Client: Persimmon Homes Thames Valley
Project Title: 19163- Sites A2 & B6 Littlehampton, West Sussex
Rev: - 1st Issue
Date – 14th May 2020

**Drainage Consultee Response for Residential Development at Hampton Park,
Parcels A2 & B6, Toddington Road, Littlehampton. Ref LU/90/20/doc**

Flow Control Chamber HB1

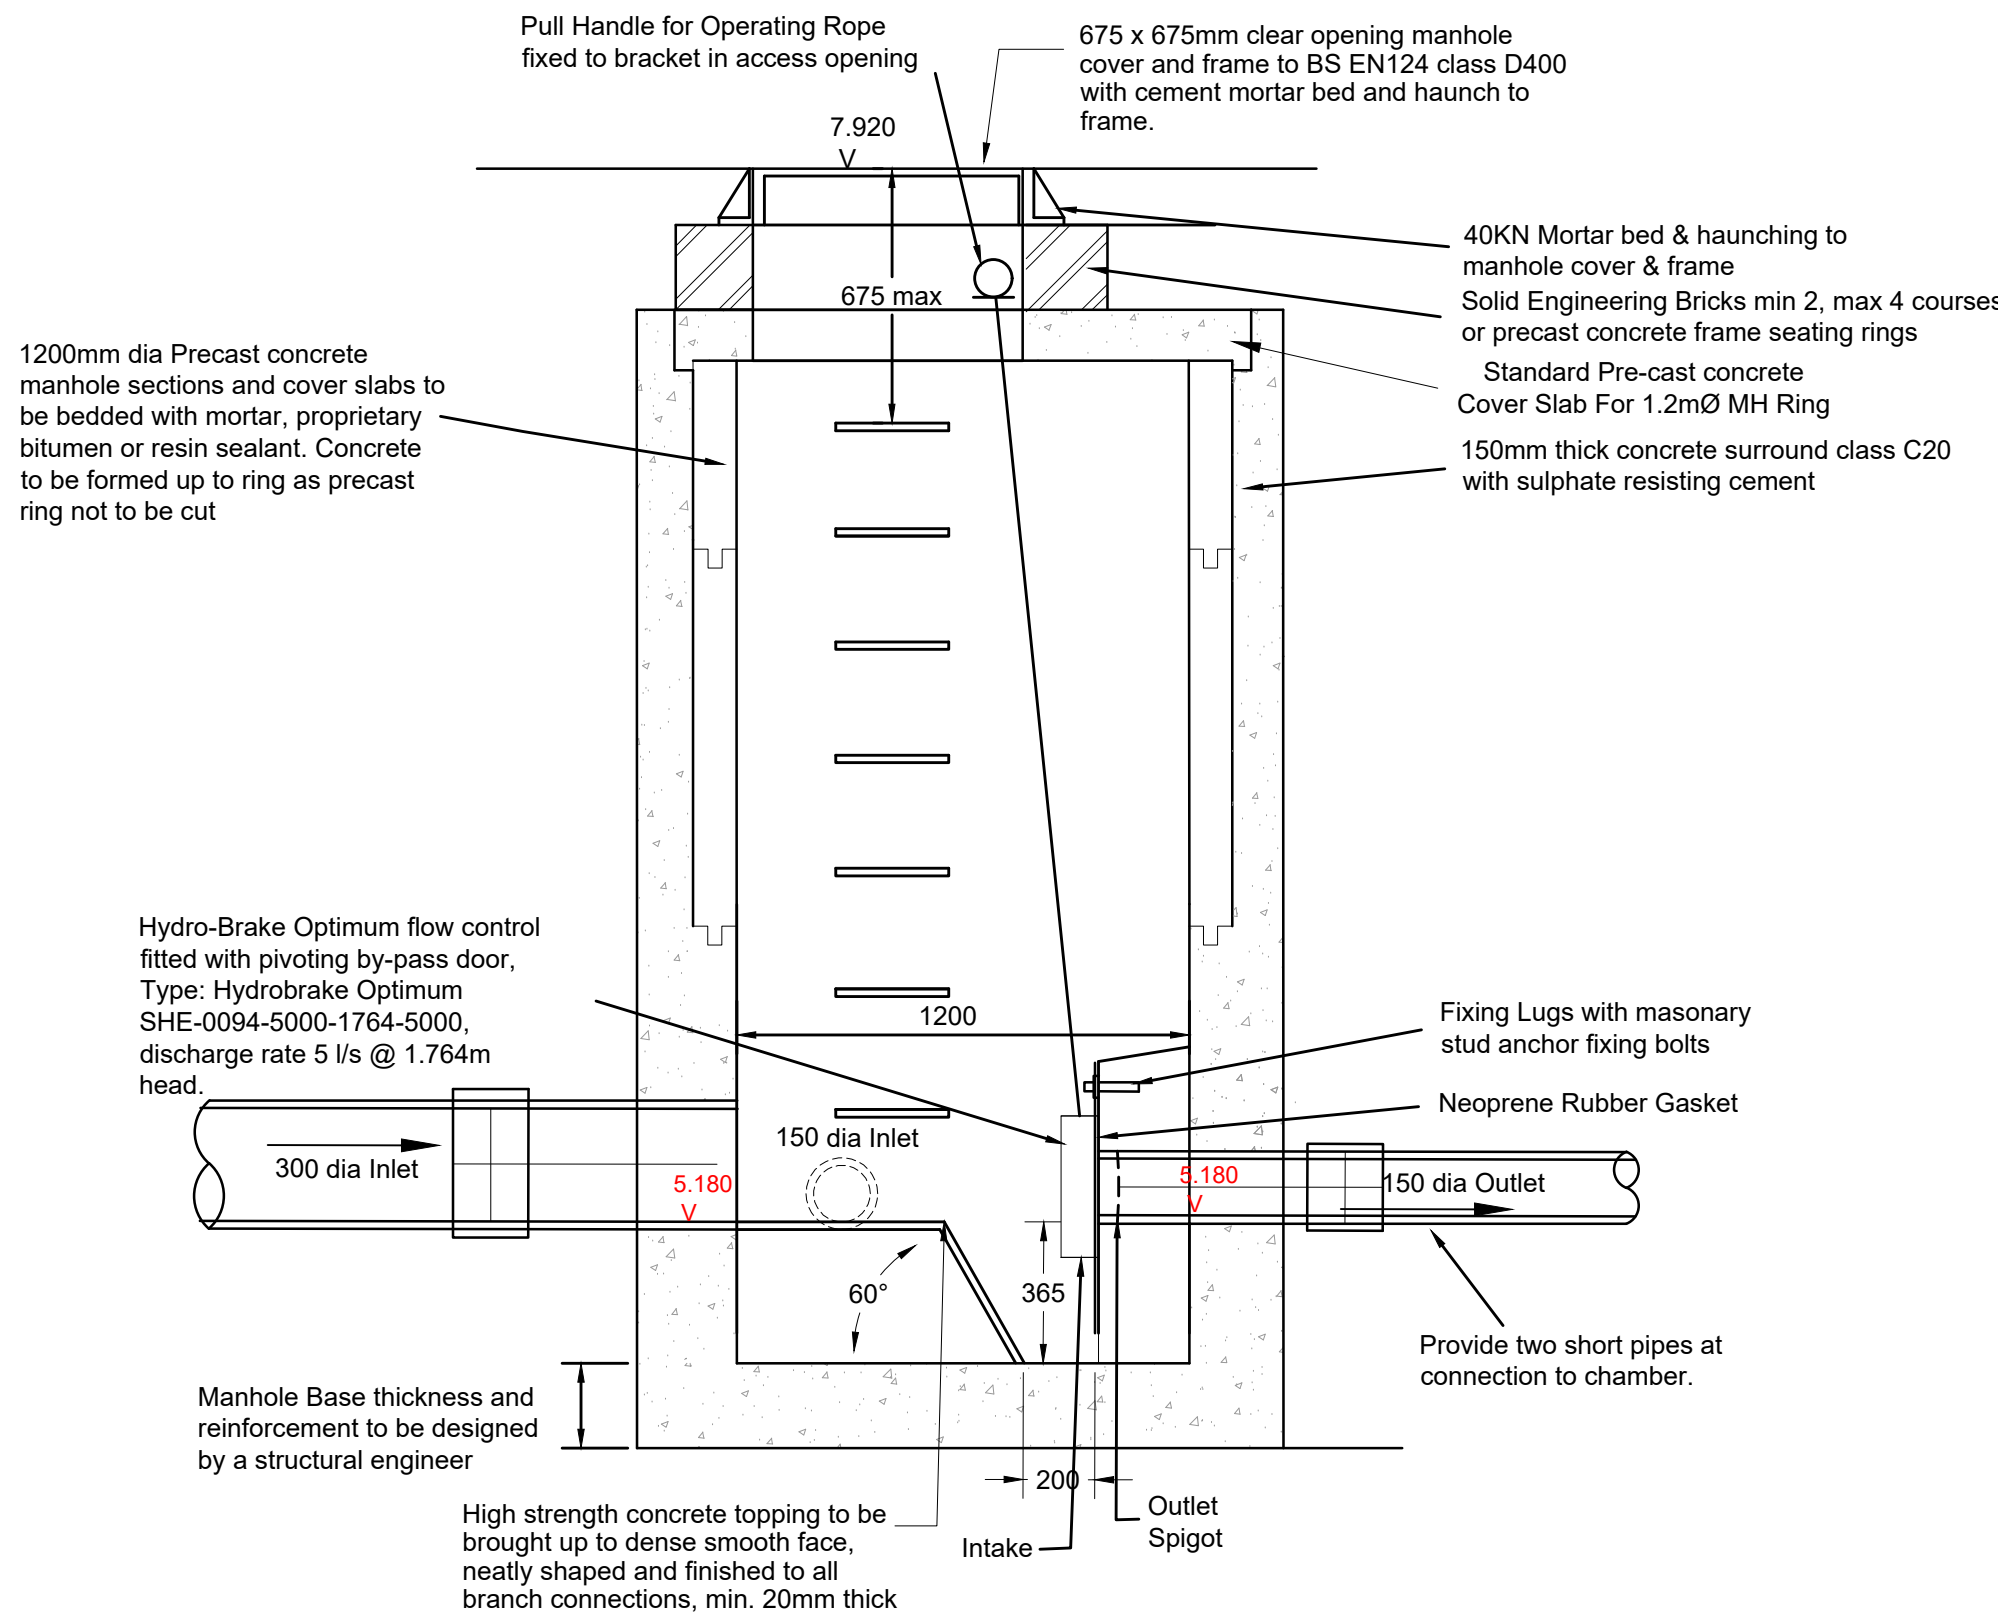
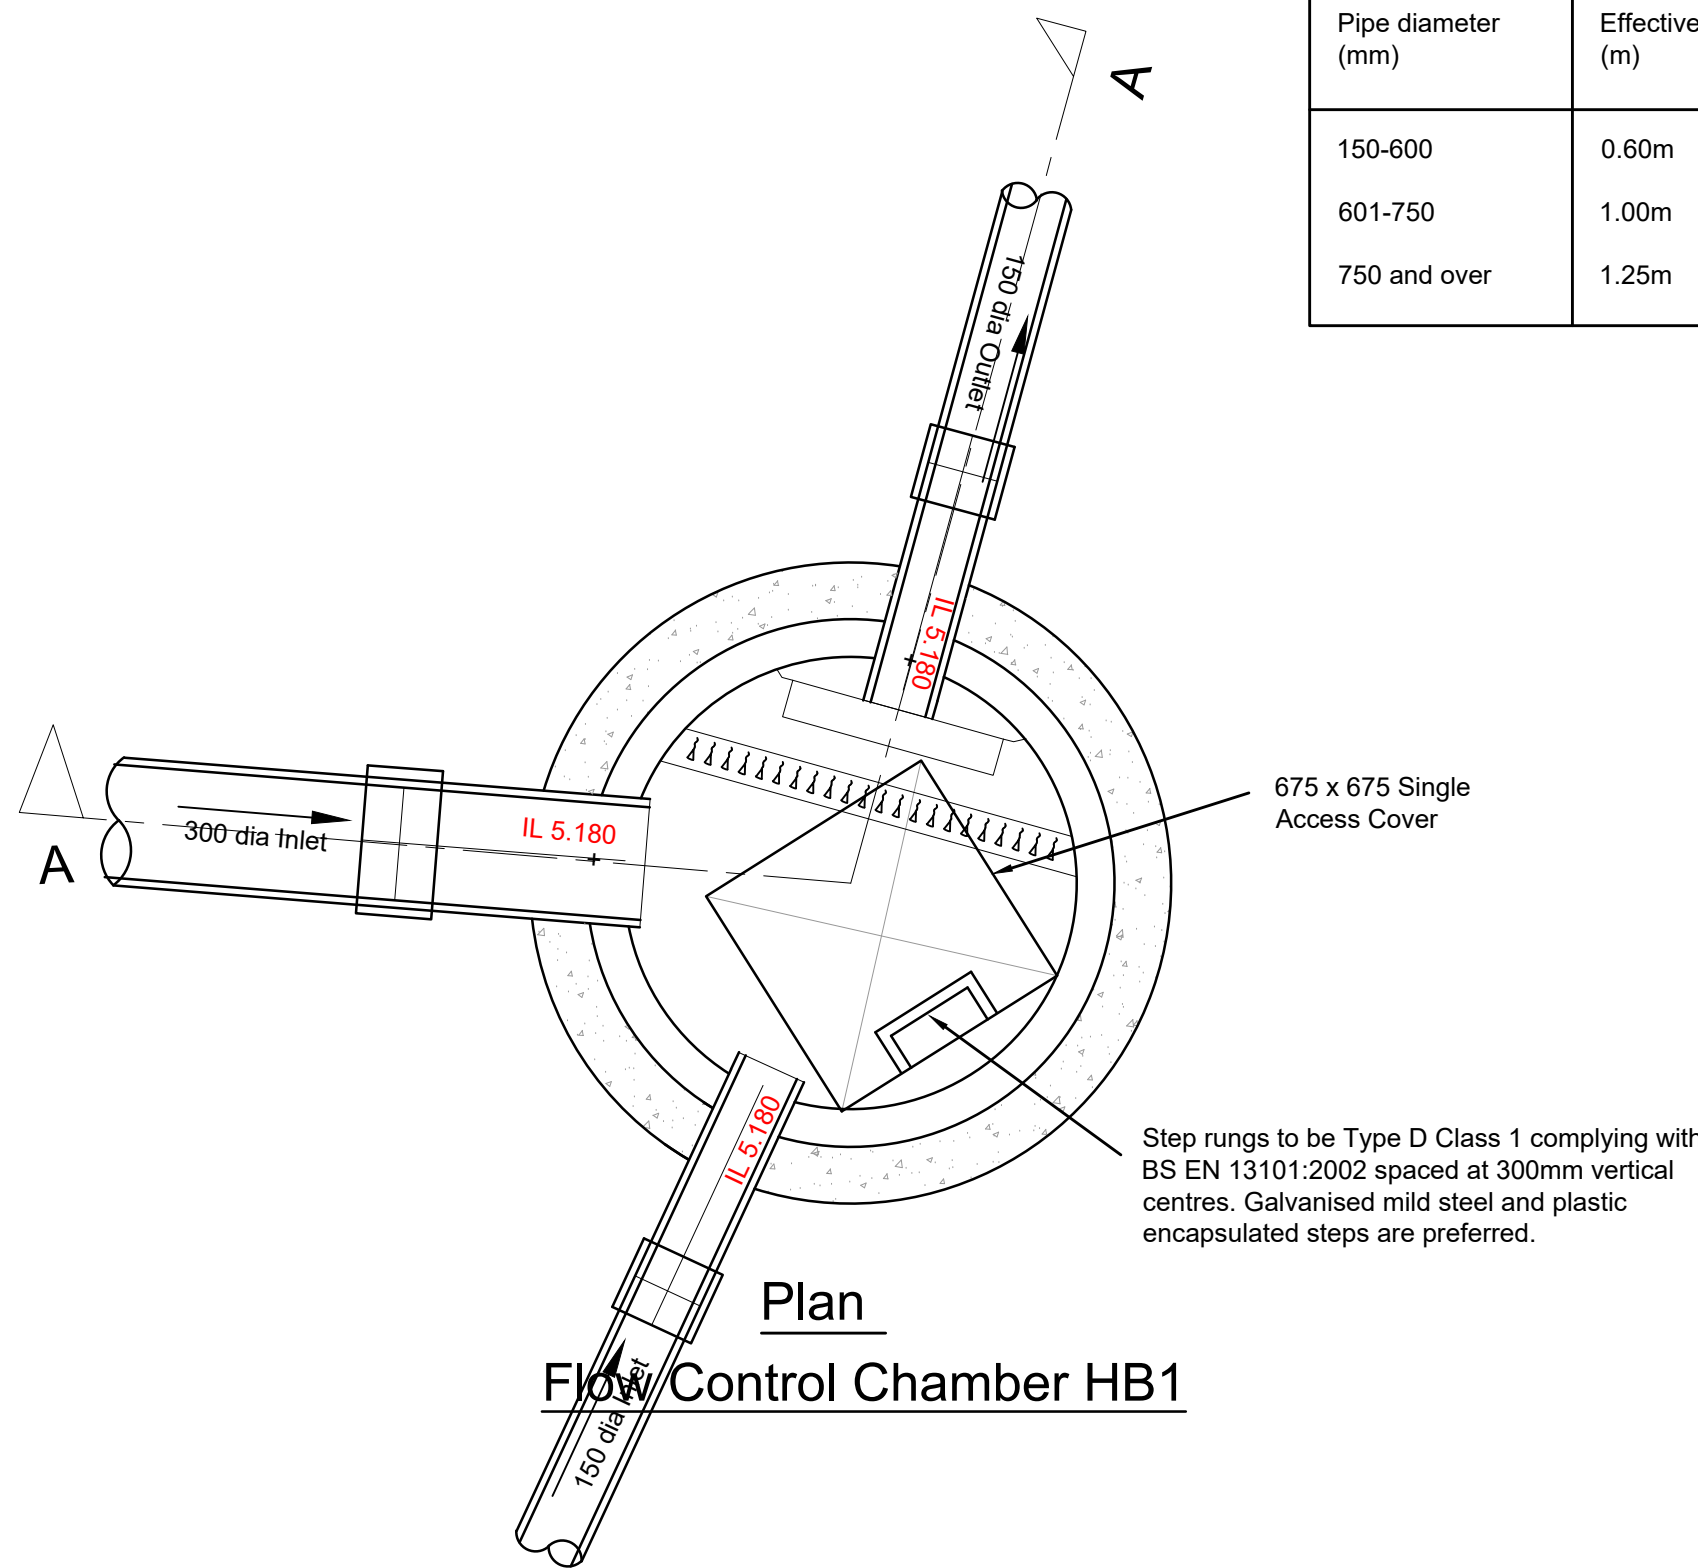
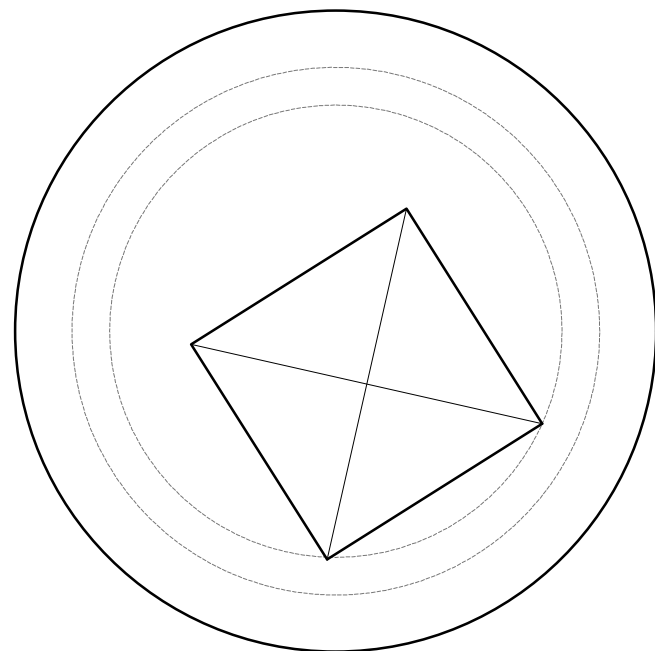
4. *Indicate allowable discharge rates on the plans and provide hydrobrake technical data sheets from the manufacturer. Allowable discharge rates indicated on drawing no 19163/100S104 at control chambers. Hydrobrake tech data sheets and Construction details are contained within Appendix D.*
